From: Anita Gardner
Sent: 27 November 2015 12:07
To: Planning.Responses
Subject: FW: 14-136 Blaber House, Angmering Mrs A Gardner ** revised drawings **
Importance: High

Please find attached revised drawing and Location Plan both marked as revision A.

Drawing Title
Plans and Elevations
as Proposed

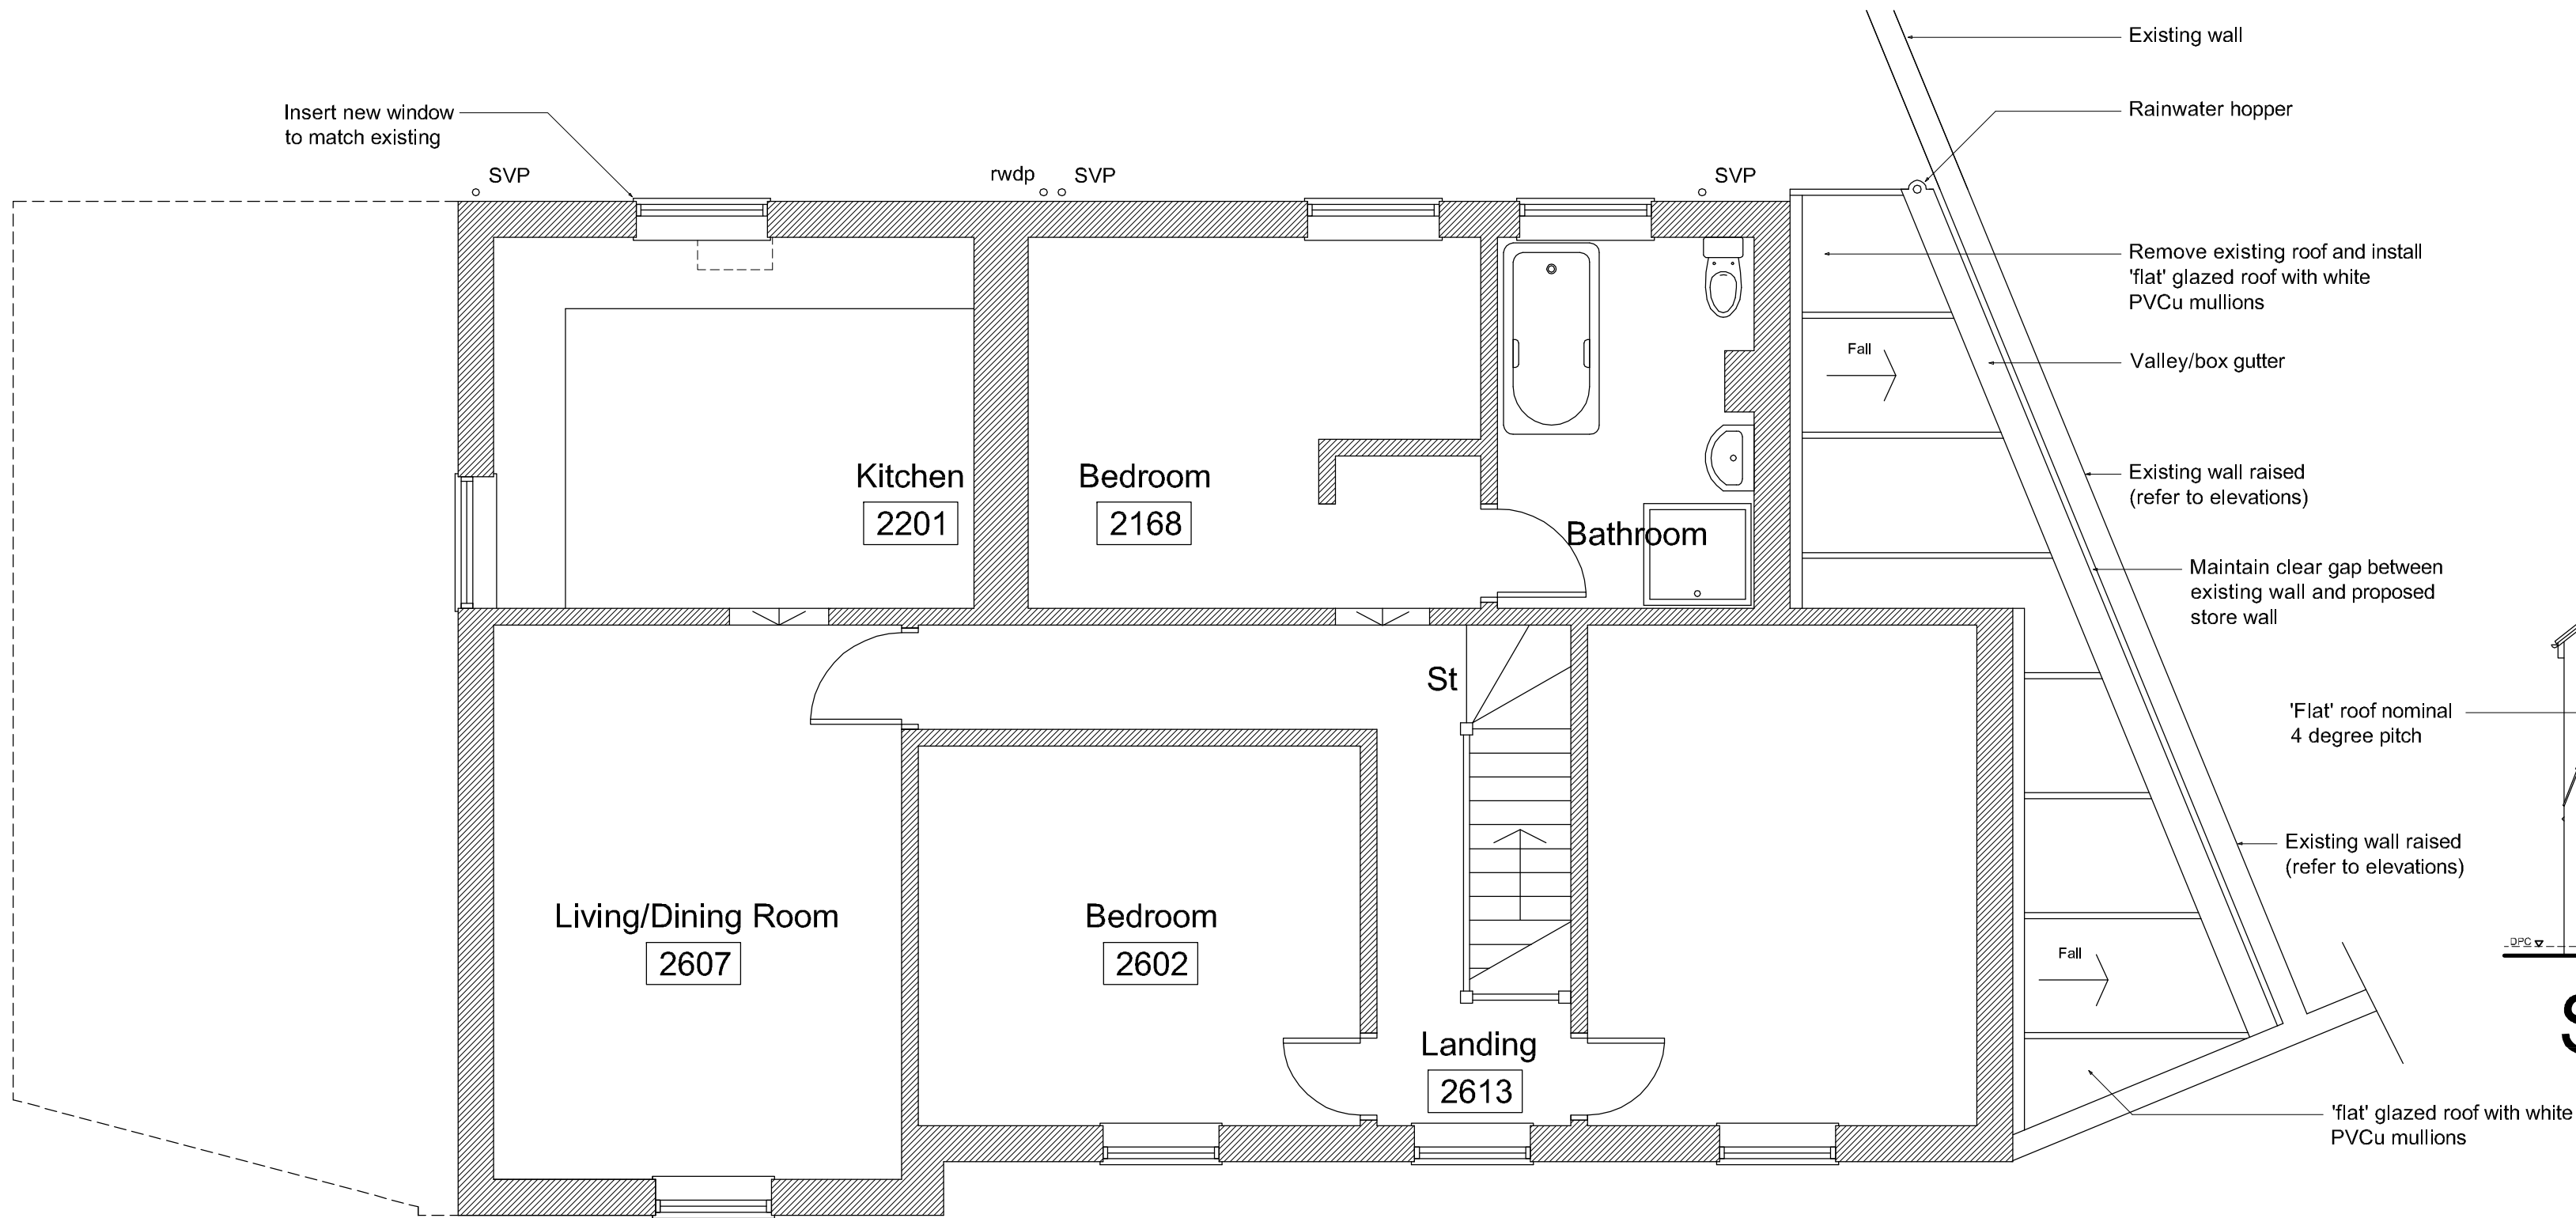
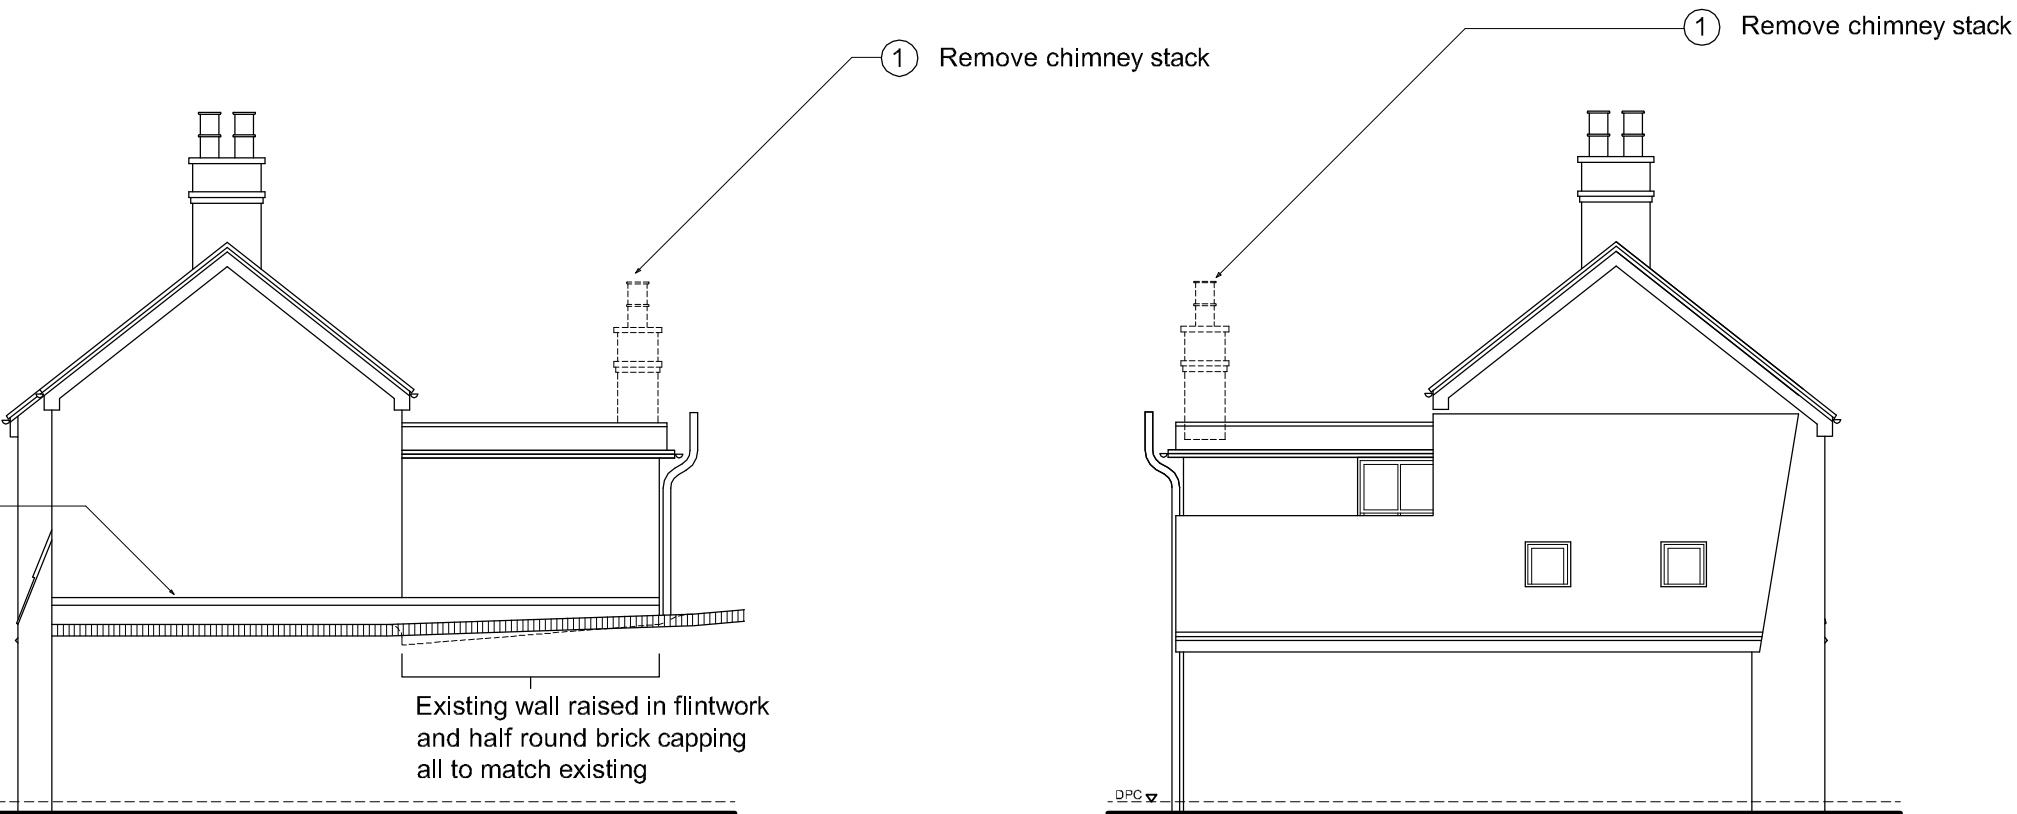
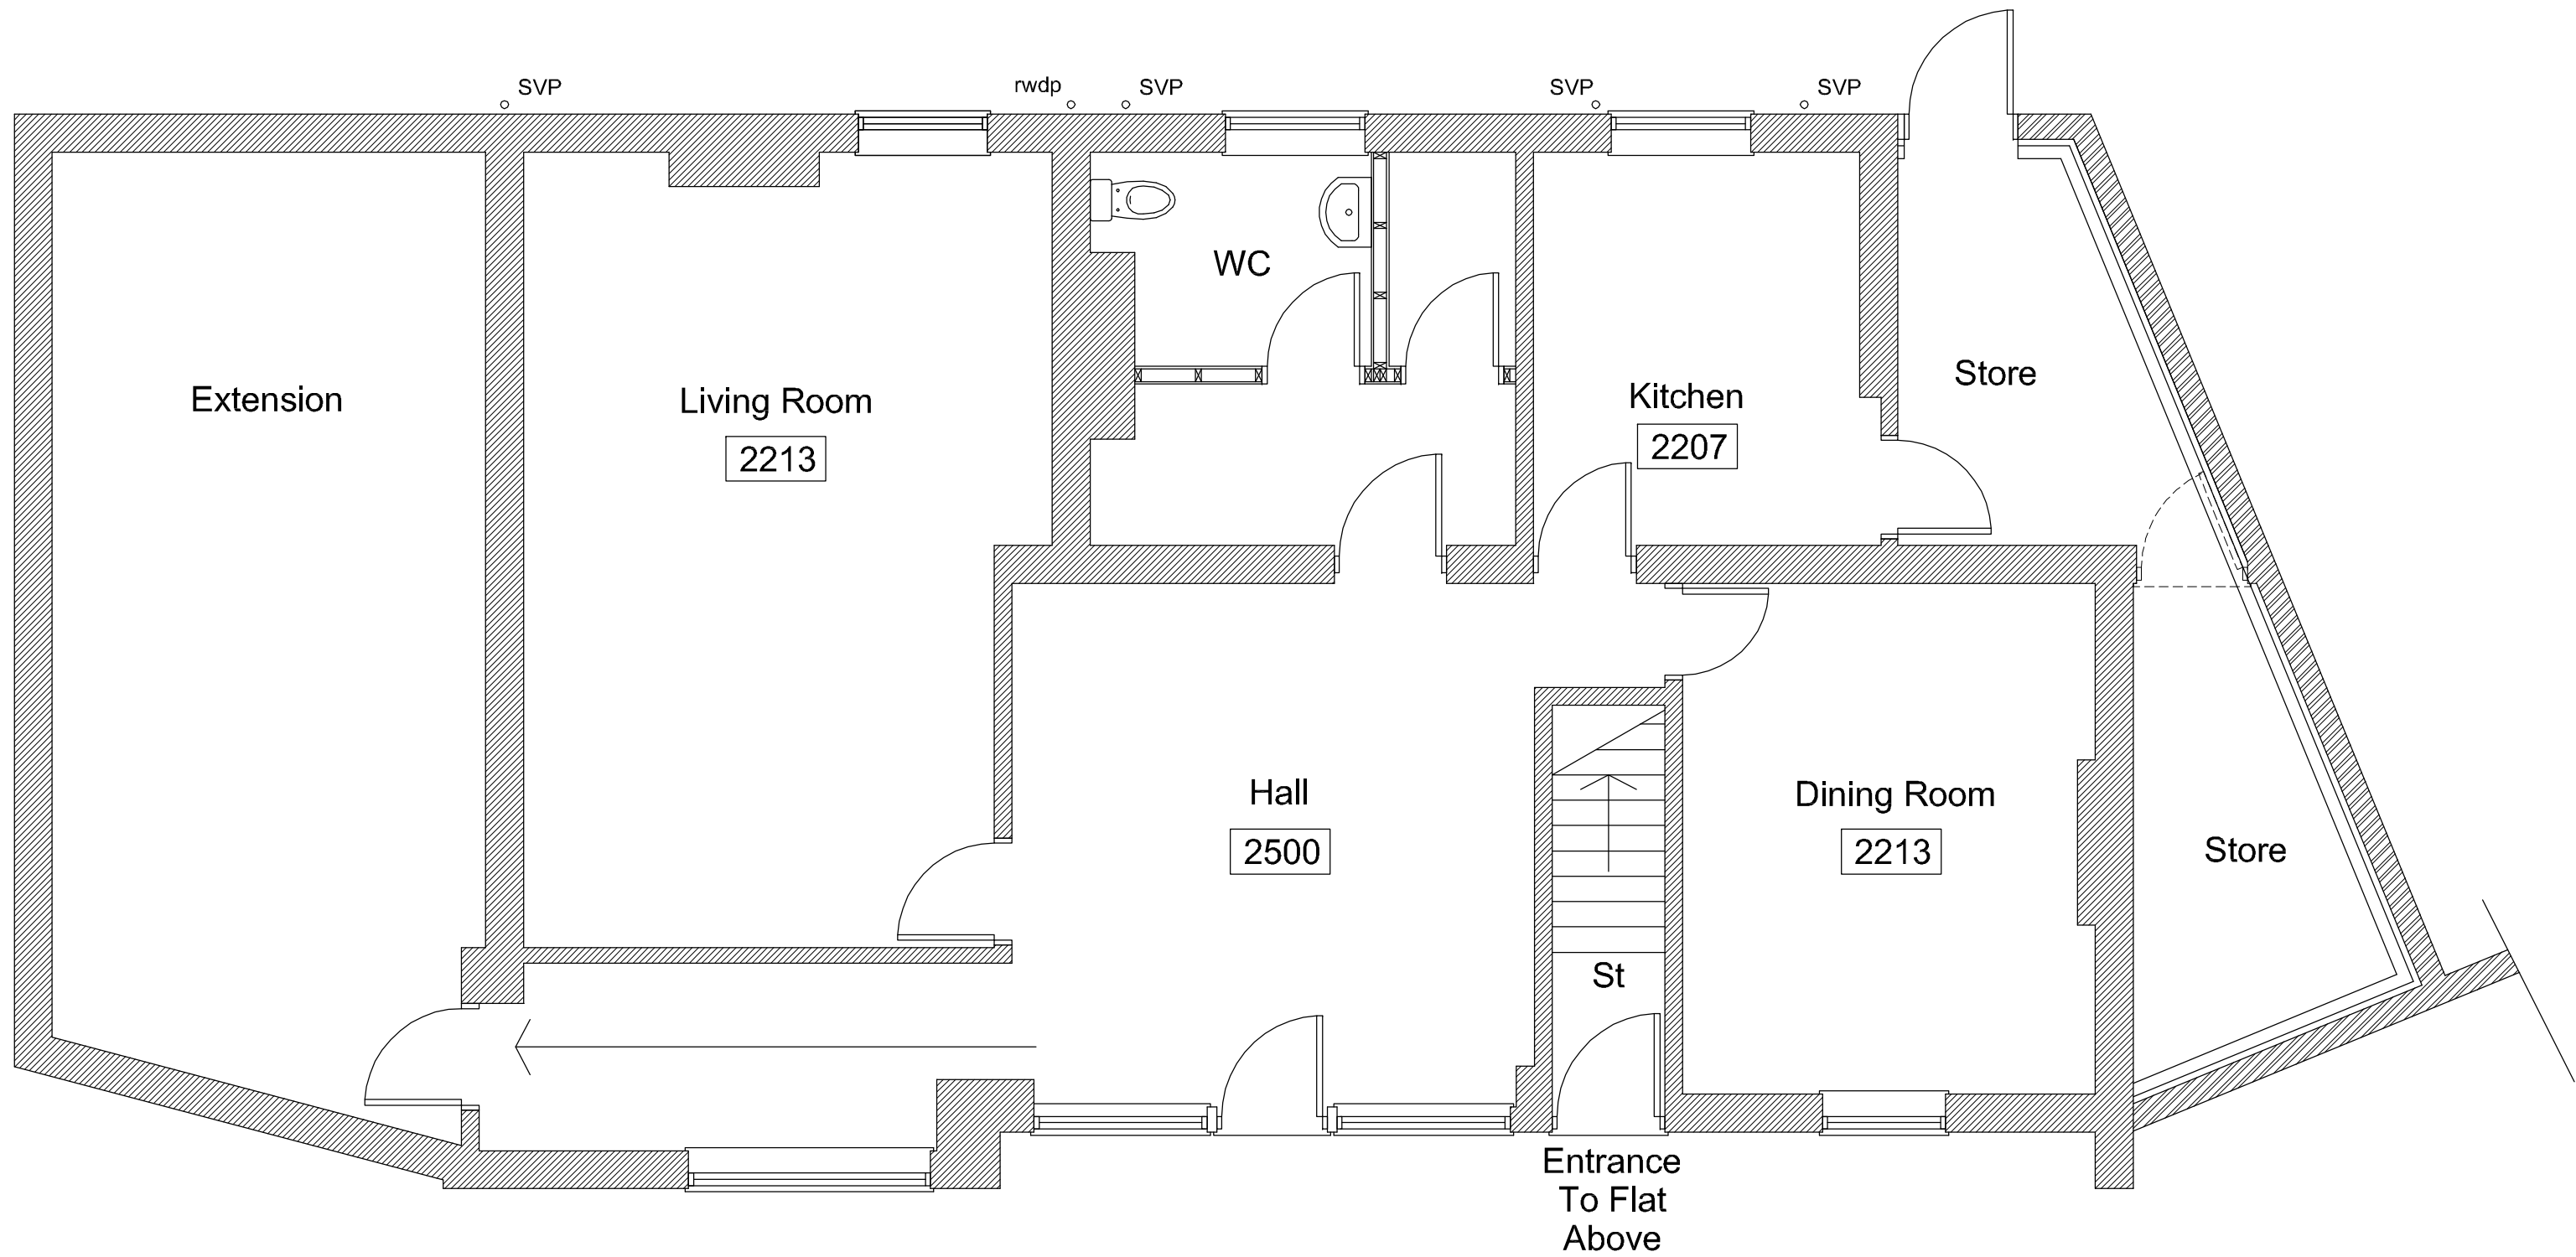
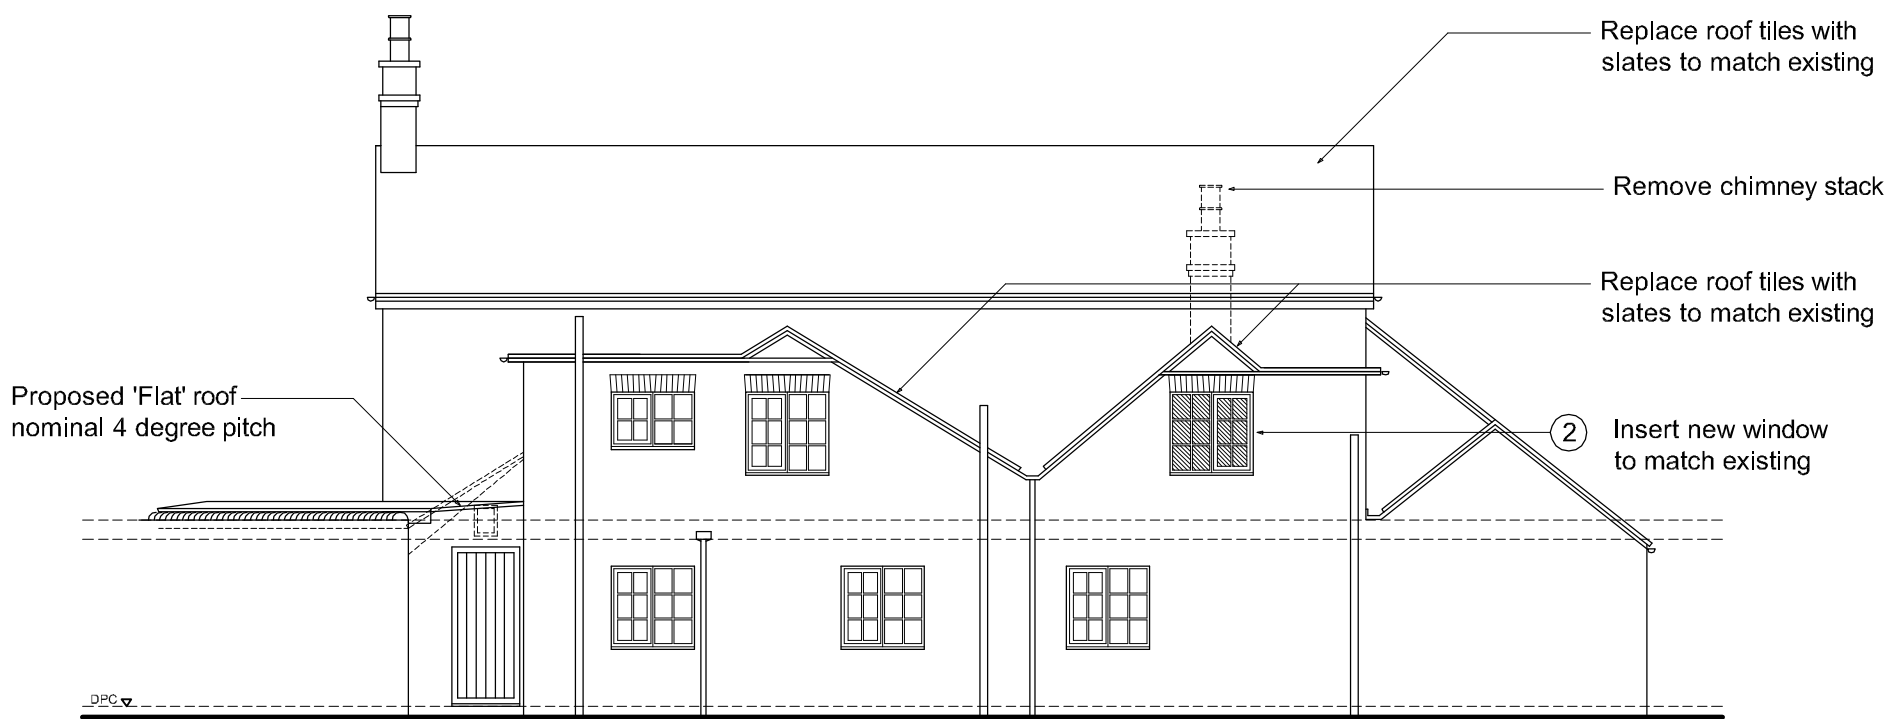
I have omitted the stack to the rear, re-instated the valley and pitched roof to the rear and included a short justification note for the removal of the rear stack and proposed window.
I have also removed all reference to the sign age as requested.
